Office of Environment & Heritage

Our Ref: DOC16/607952
Your Ref: MP07_0026 MOD5

Re: Modification of Concept Approval Major Project 07_0026 (MP07_0026)

EPIQ LENNOX HEAD ILLUSTRATION C2 GREEN NETWORK

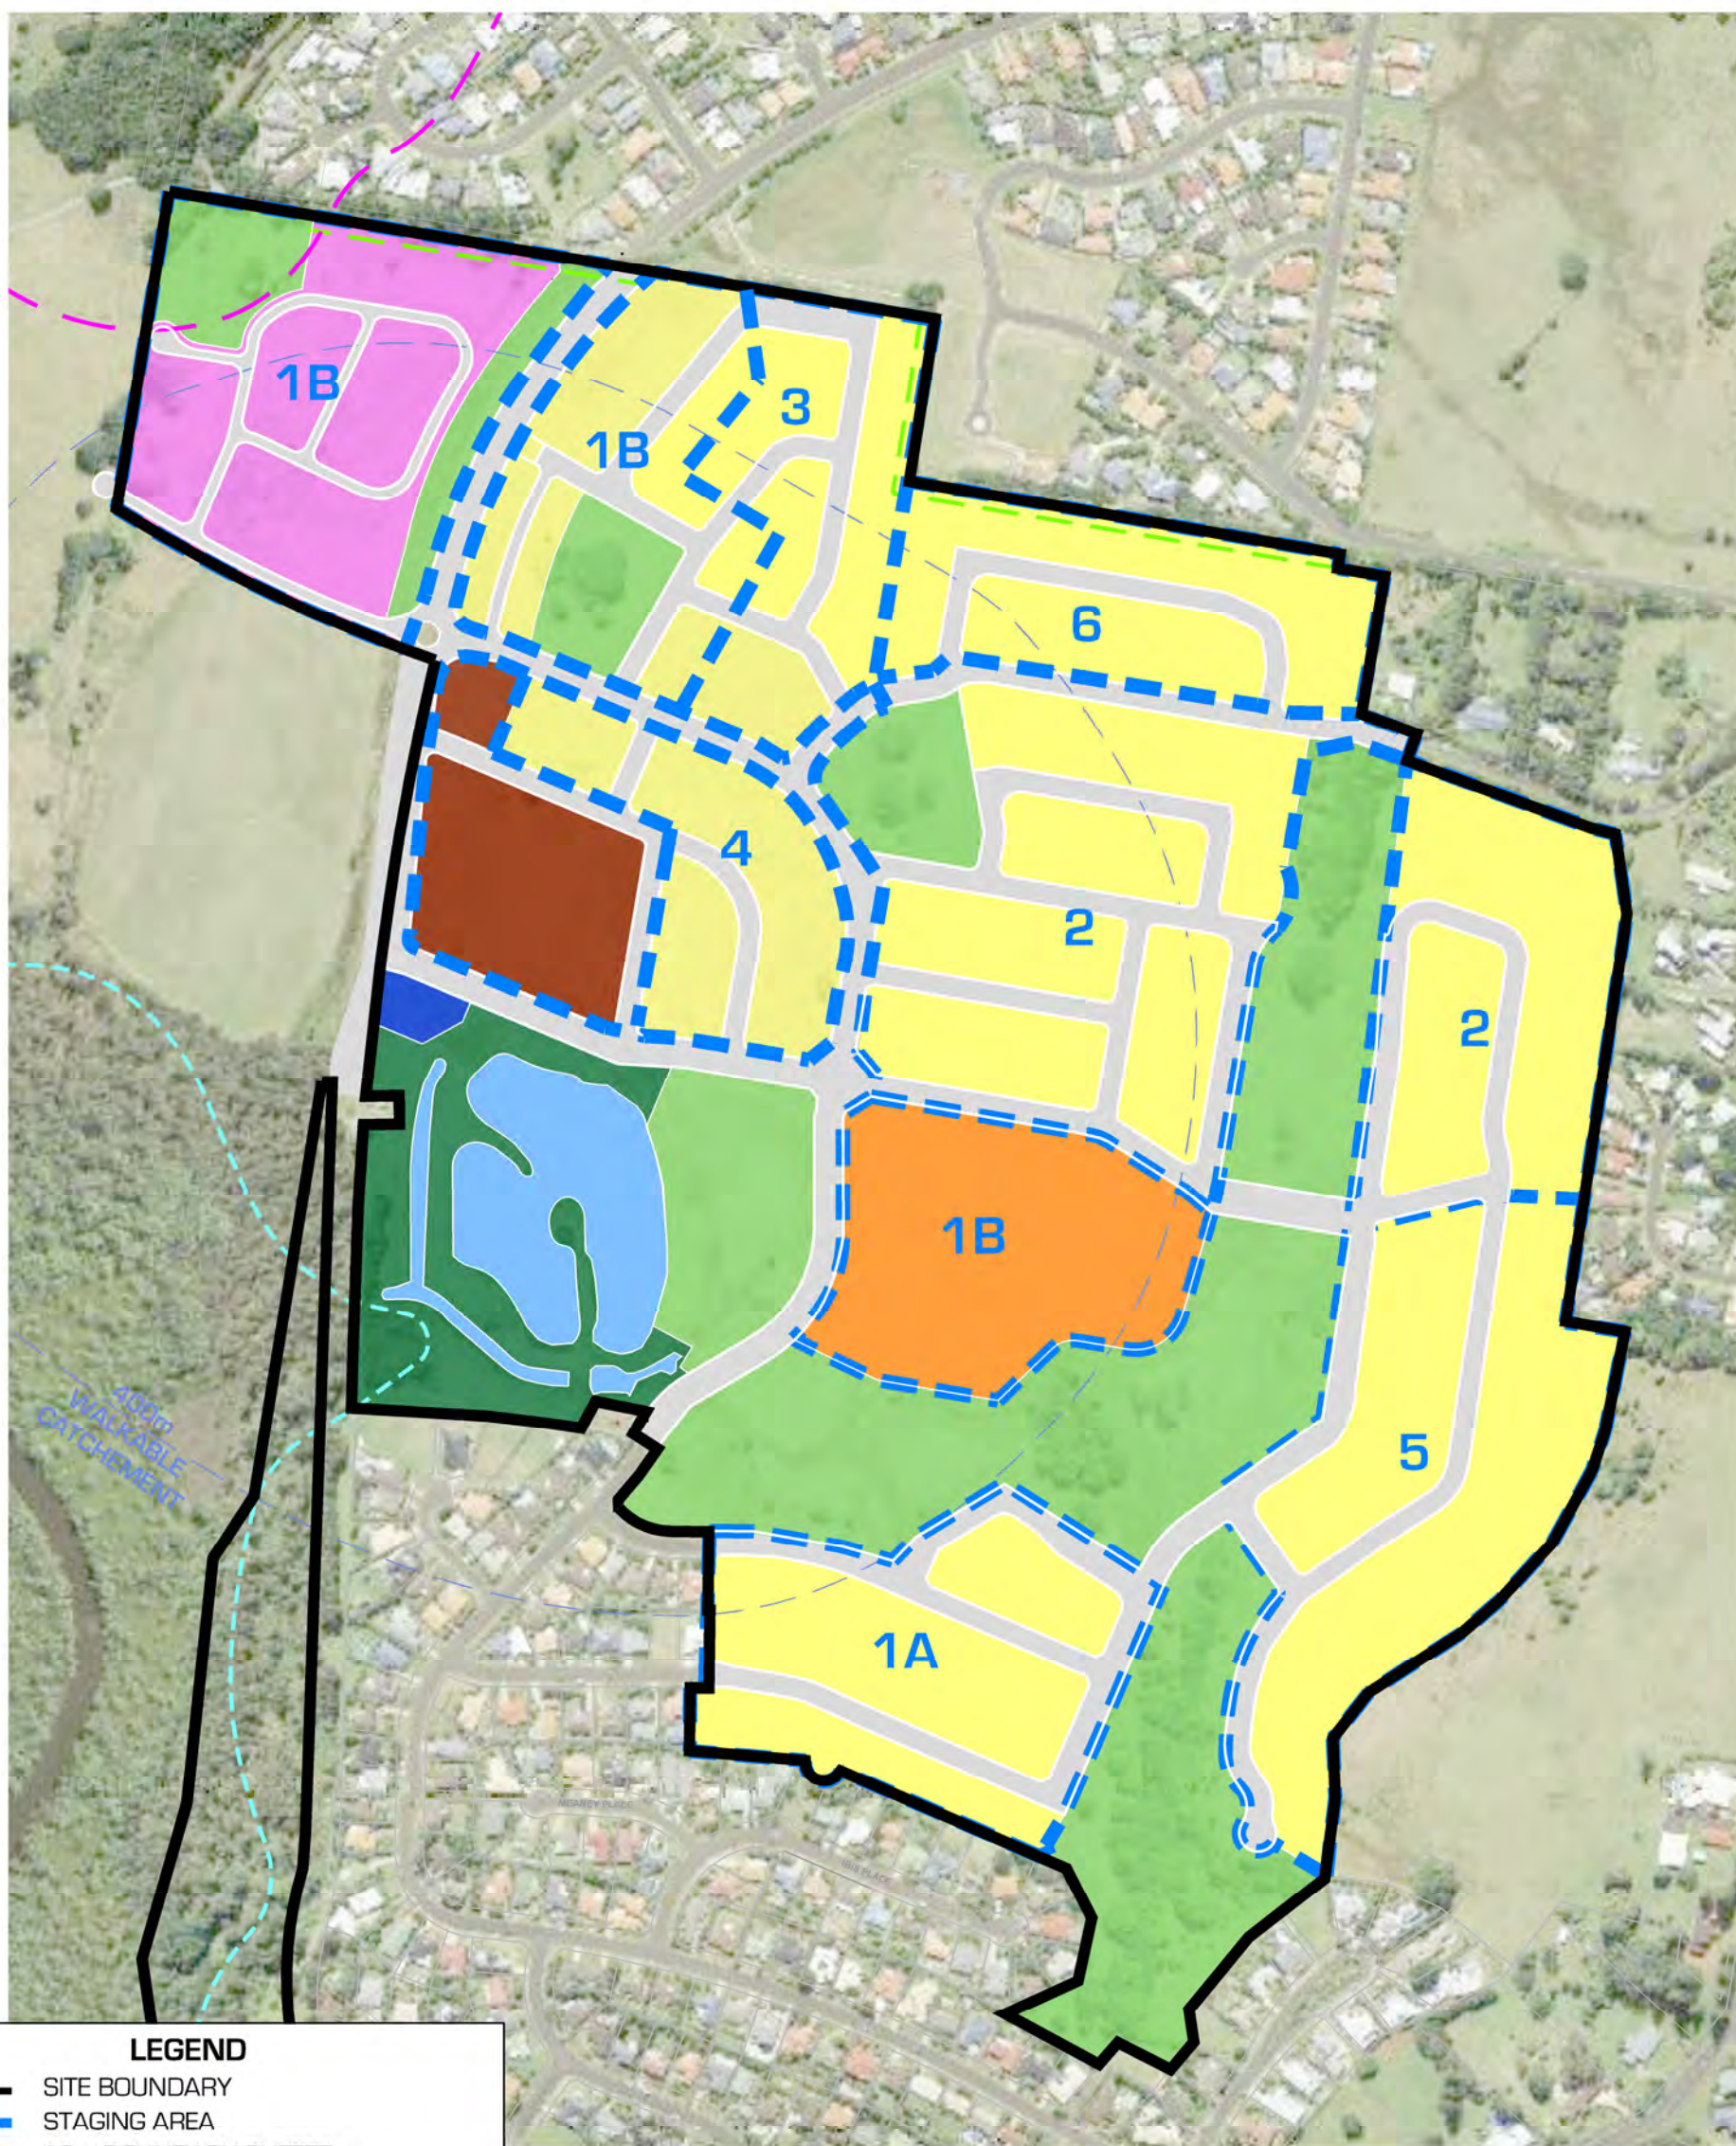
The proposal (MOD 5) appears to adjust the boundary to the northern most "Fig Park", in that, it reduces the area set aside to protect the large Morten Bay Fig *Ficus macrophylla* and other mature native trees onsite. Mr Chapelle also advised that the council consent for this stage has reconfigured the public access to run between lot boundaries and the fig park, thereby creating better separation between land uses. The OEH agrees that the council-approved layout achieves better conservation outcomes for the fig park in this part of the site.

EPIQ LENNOX HEAD
ILLUSTRATION
C11 - CONSERVATION ZONE

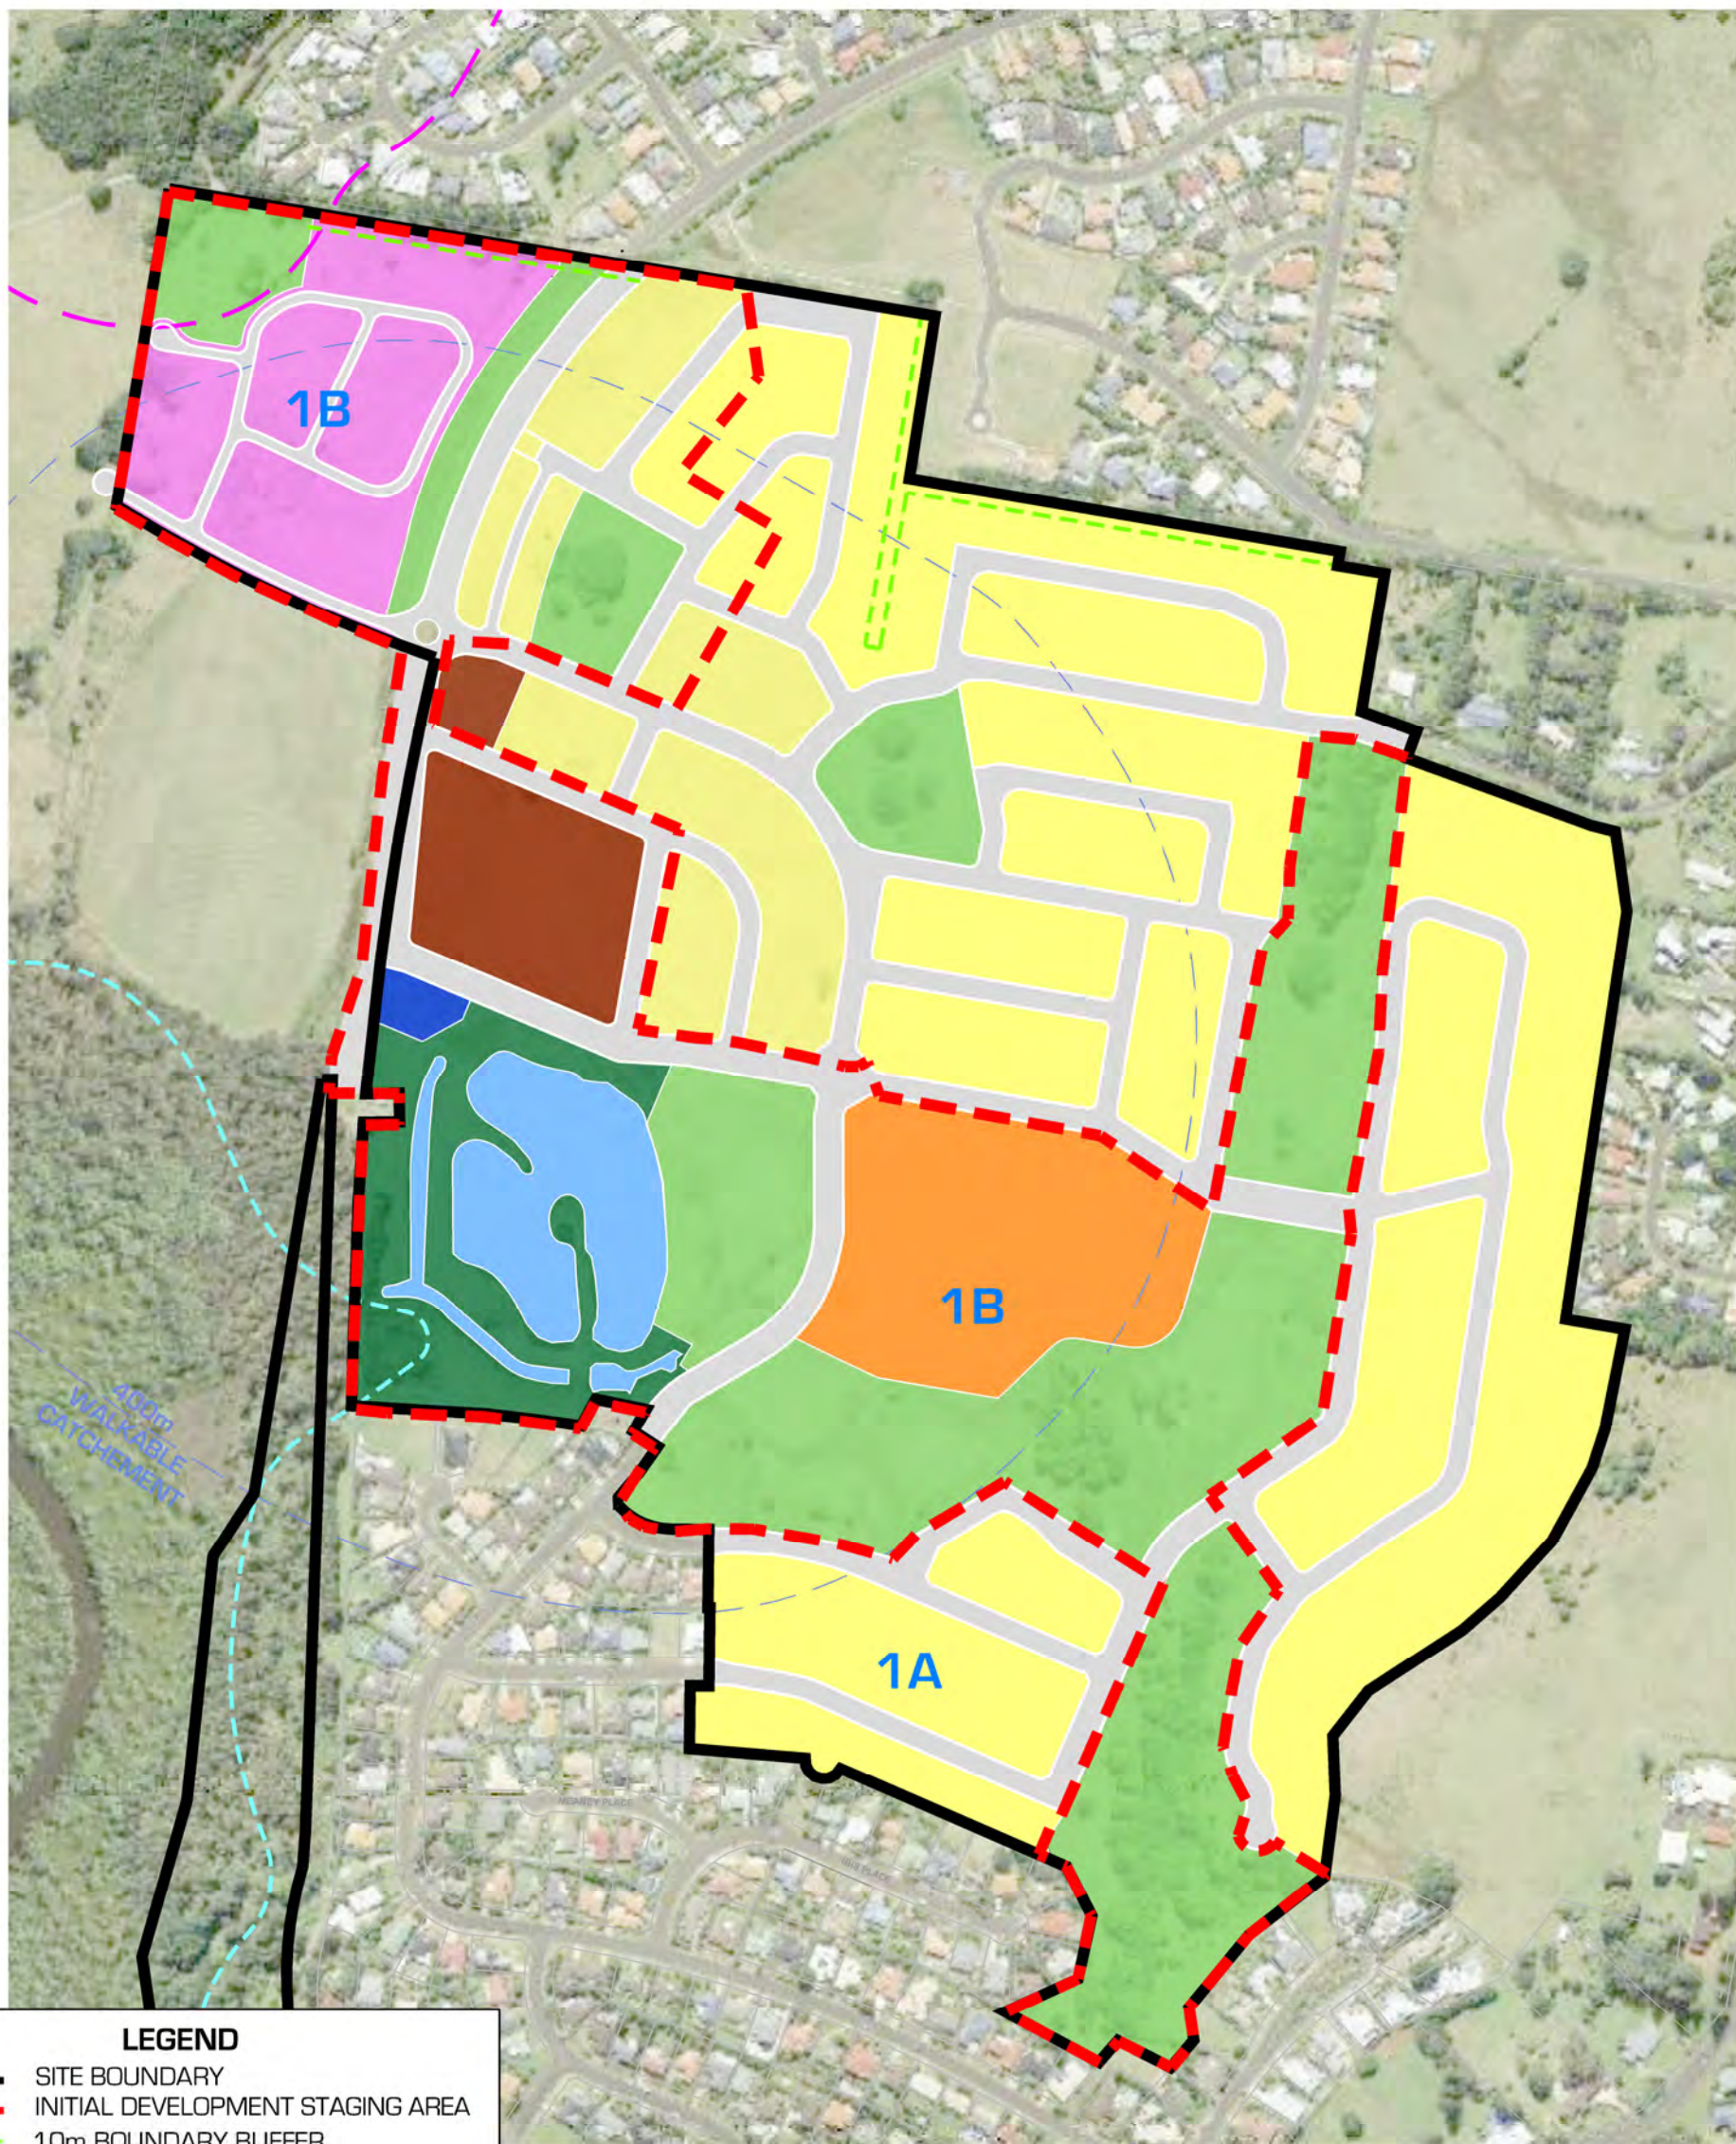
The proposed amendments in MOD 5 contain maps that suggest removal of a buffer zone and vegetation protection covenant over a remnant of Littoral Rainforest EEC and identified habitat for Arrow Head Vine *Tinospora tinosporoides* listed under the TSC Act on site. This removal was not described in the documents supporting MOD 5.

Discussions with the Department of Planning and Environment (DPE) and with the proponent's planning consultant, Mr Damian Chapelle (Newton Denny Chapelle), confirmed that there is an error in the maps provided with MOD 5. The maps show that the buffer or protective covenant to this area of high biodiversity value has been removed, but the text in the modification report does not describe this aspect of the proposal.

1. The maps attached to MOD 5 should be amended to show that the Littoral Rainforest remnant and the habitat for the Arrow Head Vine are contained within the nominated boundary buffer and area of applied vegetation protection covenant consistent with previous approvals and depicted in Map C11 – Conservation Zone. The amended maps should be provided to the Department of Planning and Environment.
2. The proponent should demonstrate to the council at the development application stage that:
 - a. the proposed MOD 5 is consistent with any flood hazard or risk management plans.
 - b. the proposed MOD 5 will not adversely affect flood behaviour and result in a detrimental increase in the potential flood affectation of other areas.
 - c. structural and design measures are in place for proposed MOD 5 to manage risk as a consequence of flooding.

Mr Chapelle advised that there is no proposal to remove the buffer or protective covenant and that development consent from the Ballina Shire Council has been obtained for this stage, which includes conditions requiring protection and management of this area. He undertook to correct the maps for MOD 5 and provide the corrected version to the Department of Planning and Environment.
